WEST SUSSEX COUNTY COUNCIL CONSULTATION

TO:	Arun District Council FAO: Maria Tomalova
FROM:	WSCC - Highways Authority
DATE:	20 October 2020
LOCATION:	Rear of 7 Middleton Road, Felpham, PO22 6BL
SUBJECT:	FP/184/20/PL Demolition of existing garage/outbuilding & construction of a pair of semi-detached houses & associated works. This site is in CIL Zone 4 & is CIL Liable as new dwellings.
DATE OF SITE VISIT:	N/A
RECOMMENDATION:	Advice
S106 CONTRIBUTION TOTAL:	N/A

PL03 - Block Plan

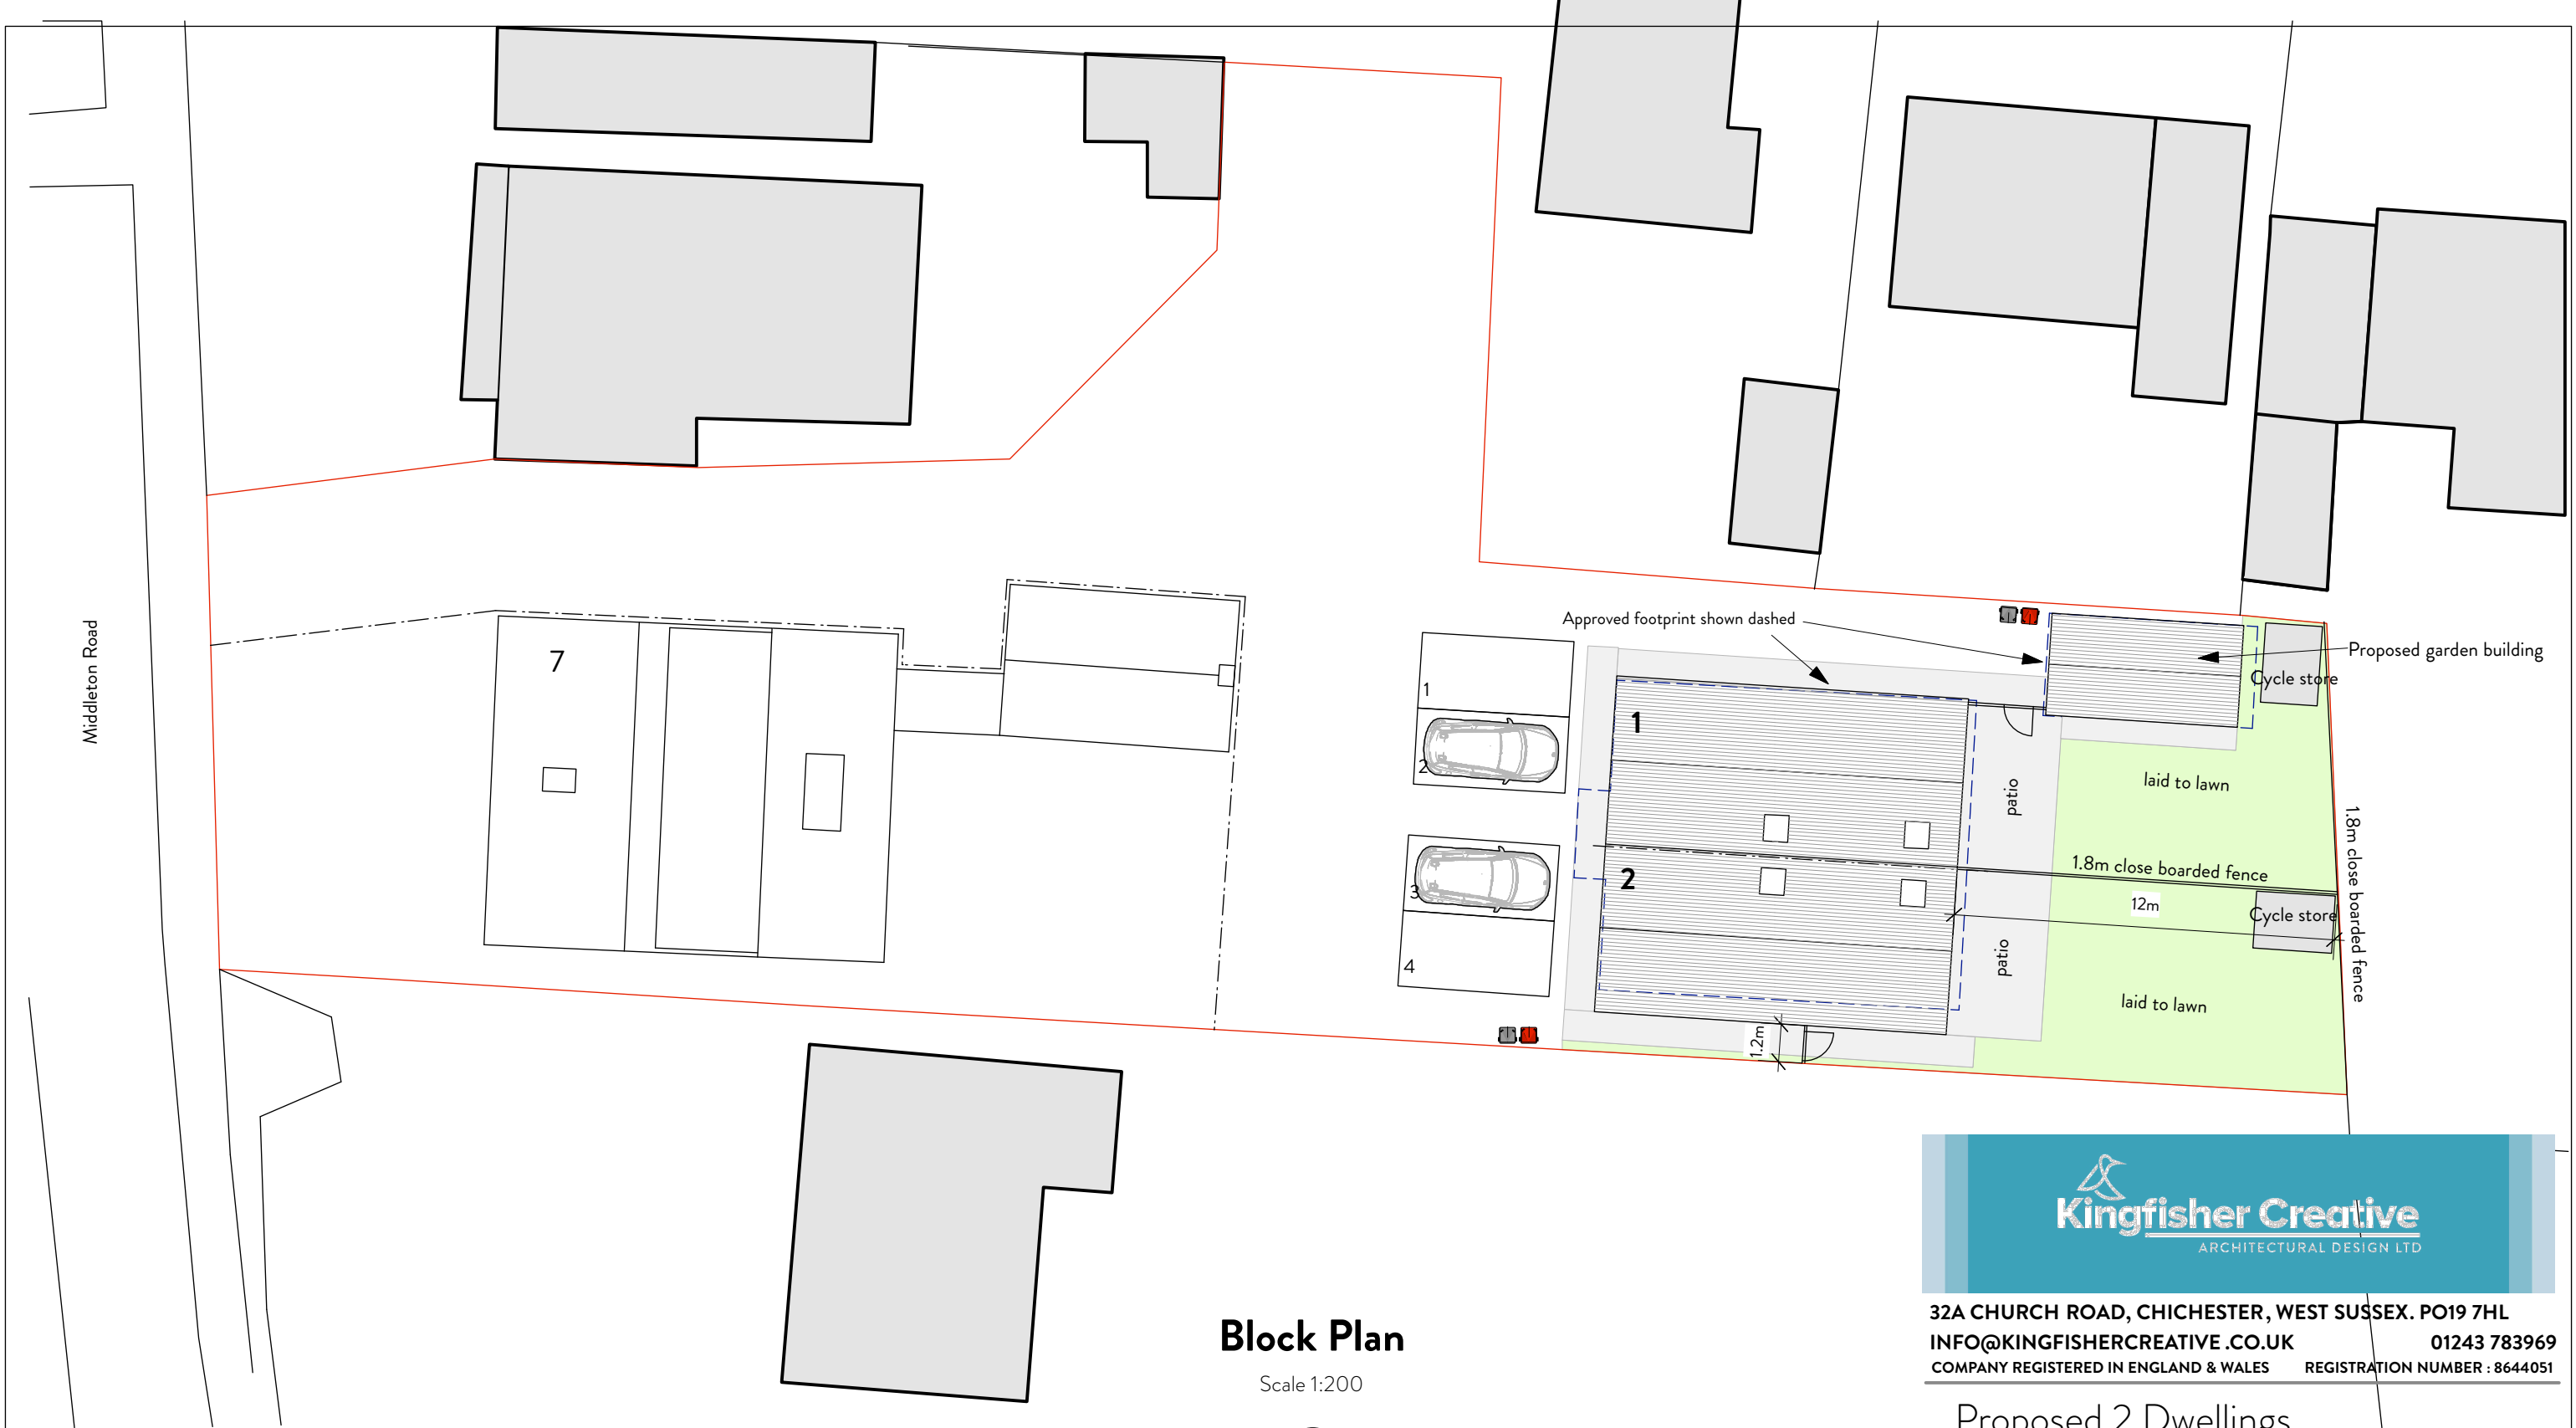
The applicant proposes two parking spaces per dwelling, totalling to four spaces for the development as a whole. Under Arun Parking Standards (2020), the LHA would expect a development of this size in this location to provide at least four car parking spaces. Therefore, the LHA considers the proposed parking provision to be sufficient.

From inspection of the plans, the four parking bays meet the minimum specifications for single car bays of 2.4m x 4.8m as set out in Manual for Streets (MfS). However, as per MfS 8.3.51, parking bays require at least 6m of space behind them to ensure that a car can manoeuvre in an out of a parking bay at 90 degrees. From inspection of the plans, there is approximately 5.7m of space. Where space is limited, it may not be possible to provide for vehicles to get into the spaces in one movement; some back and fore manoeuvring may be required. The LHA advises the applicant to ensure the parking bays have a gap of at least 6m behind, to ensure on-site turning is achievable.

The applicant has demonstrated cycle stores to the rear of both plots, in accordance with WSCC and Arun parking standards. The inclusion of secure and covered cycle parking provision helps promote the use of sustainable alternative modes of transport to the private car.
